# LSC Responses to Improvements Table Redlines

Table 7\*: Roadway Improvements  
Esteban Rodriguez Sketch Plan

Figure 7
**2030 Baseline + Site Traffic, Lane
 Geometry, Traffic Control, and LOS**

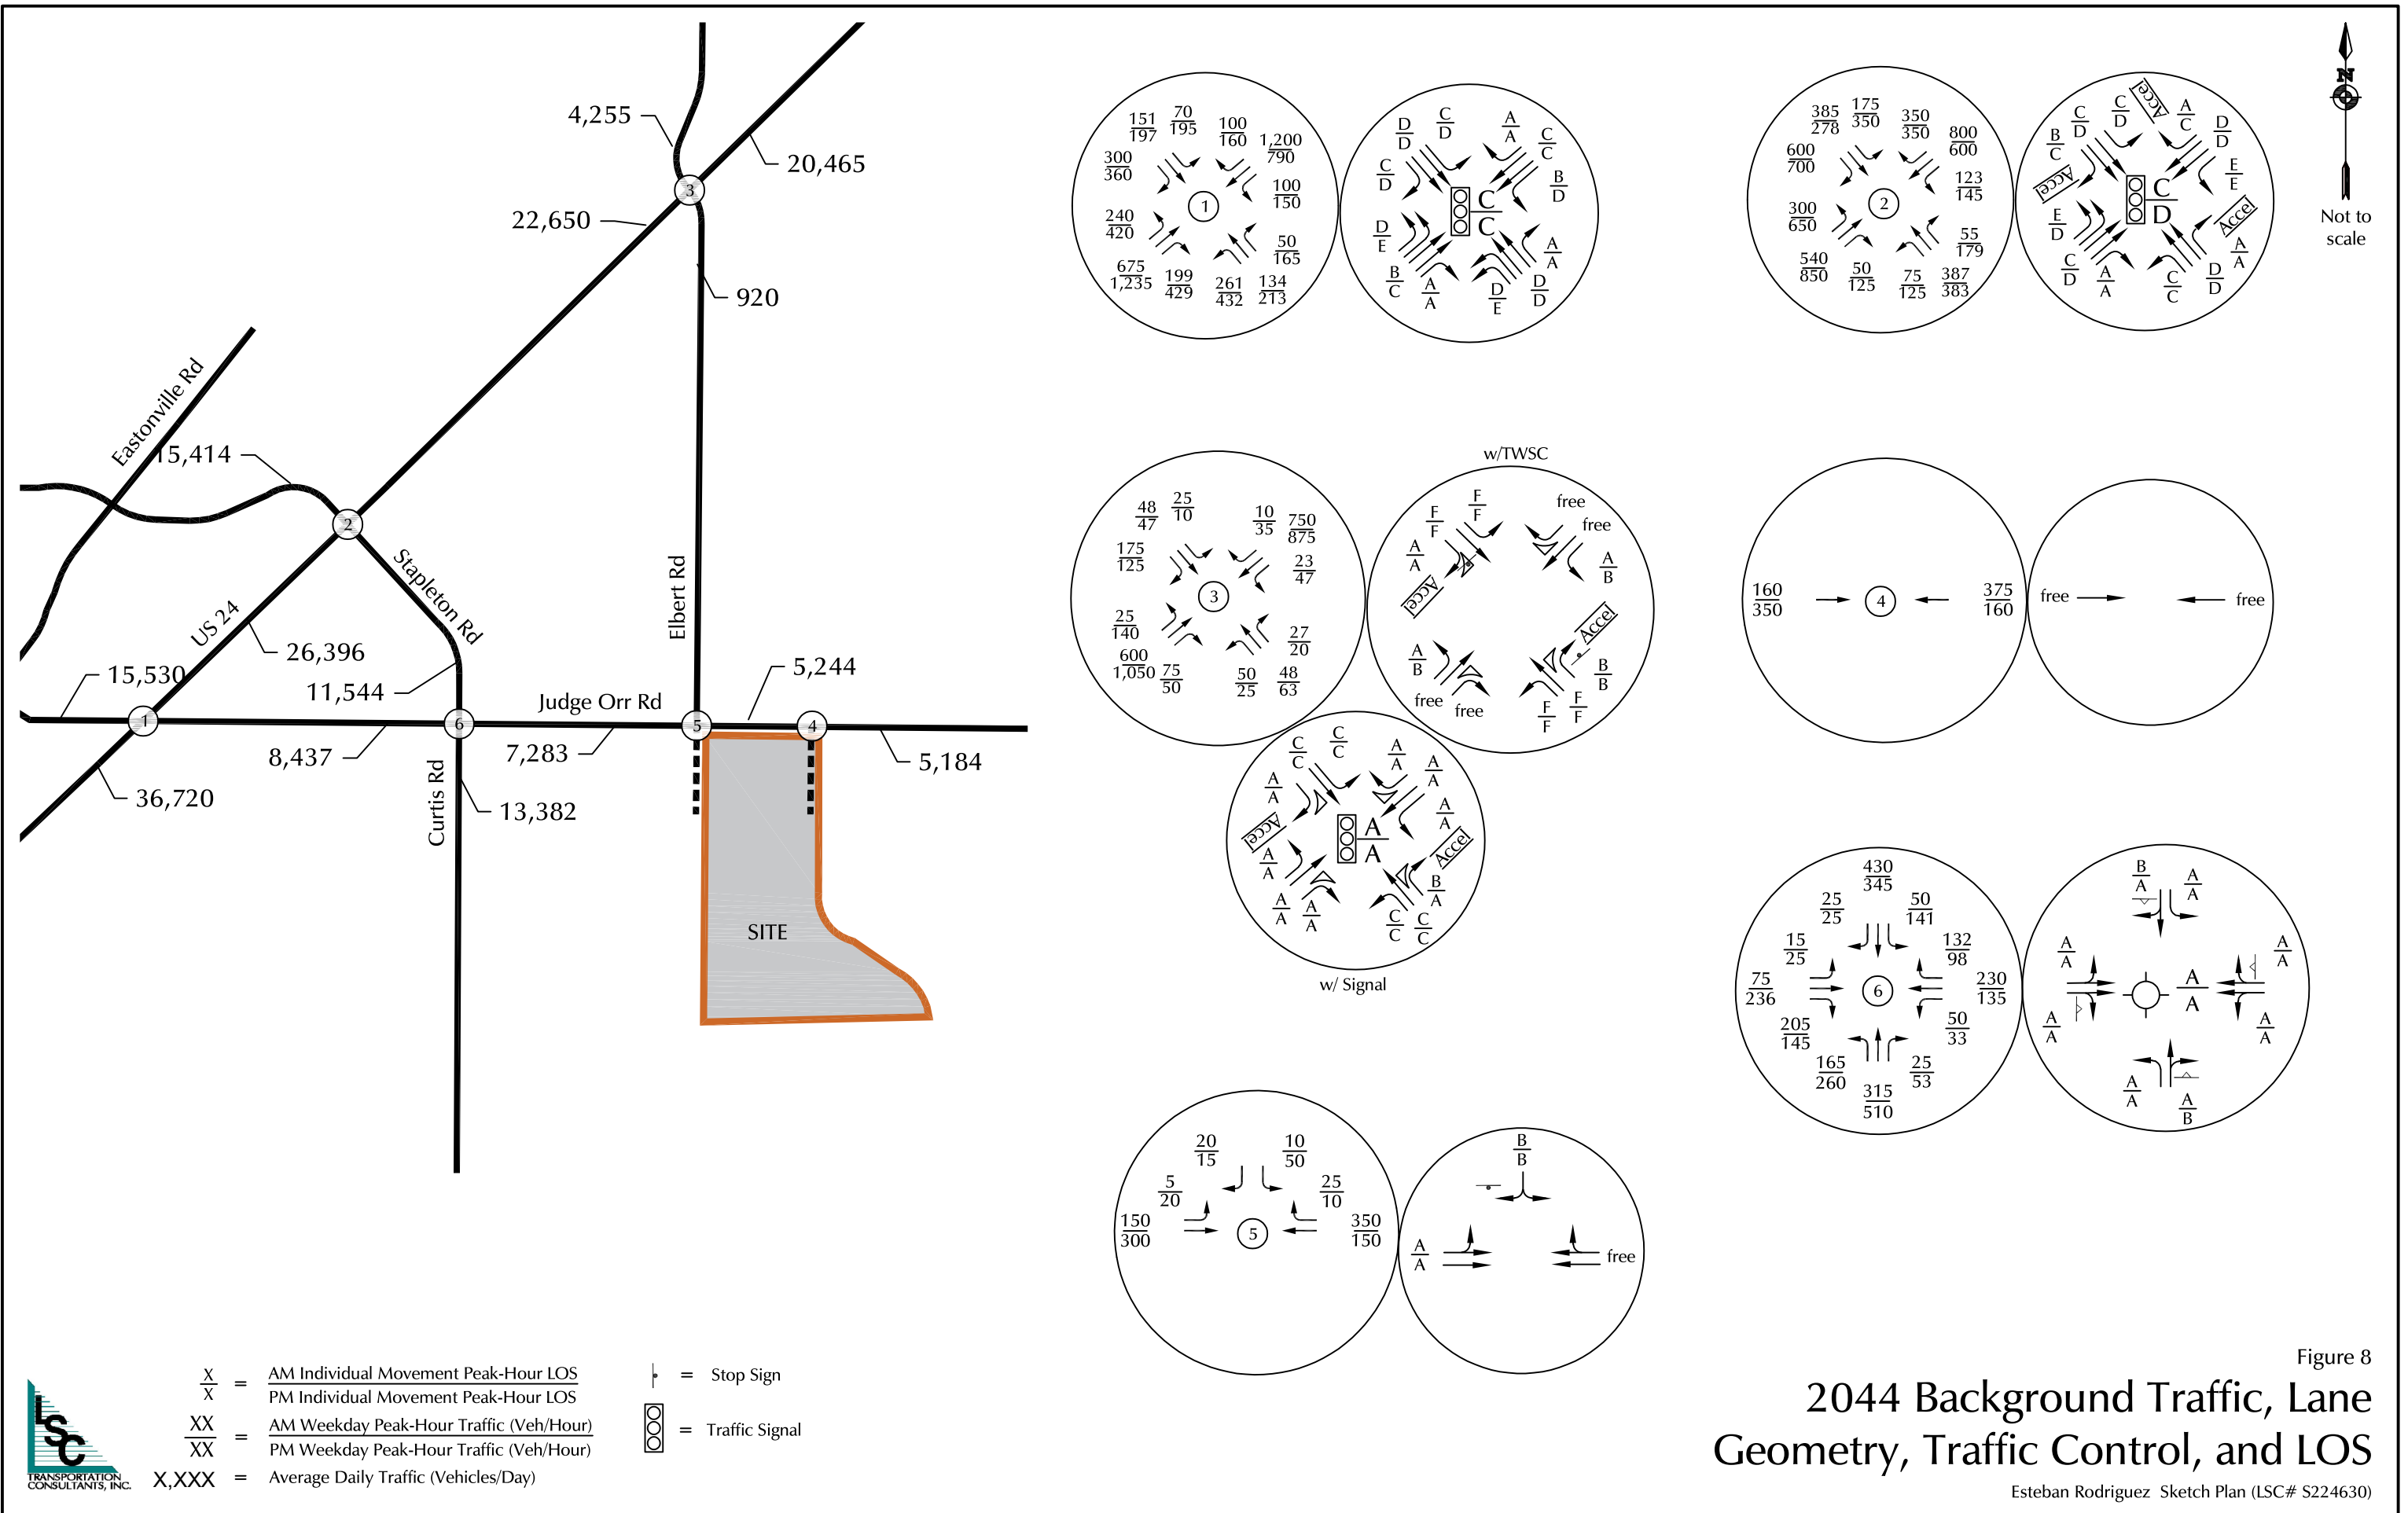
Per the volume in figure 7, an eastbound right and northbound left would be needed. Please revise the table accordingly.

👉 Author: Jeff Hodsdon Subject: Sticky Note Date: 7/31/2024 1:04:09 PM  
LSC Response: Revised as requested. We also added the potential for a deviation for the northbound left-turn lane, if this approach is likely to remain stop-sign controlled for northbound/southbound.
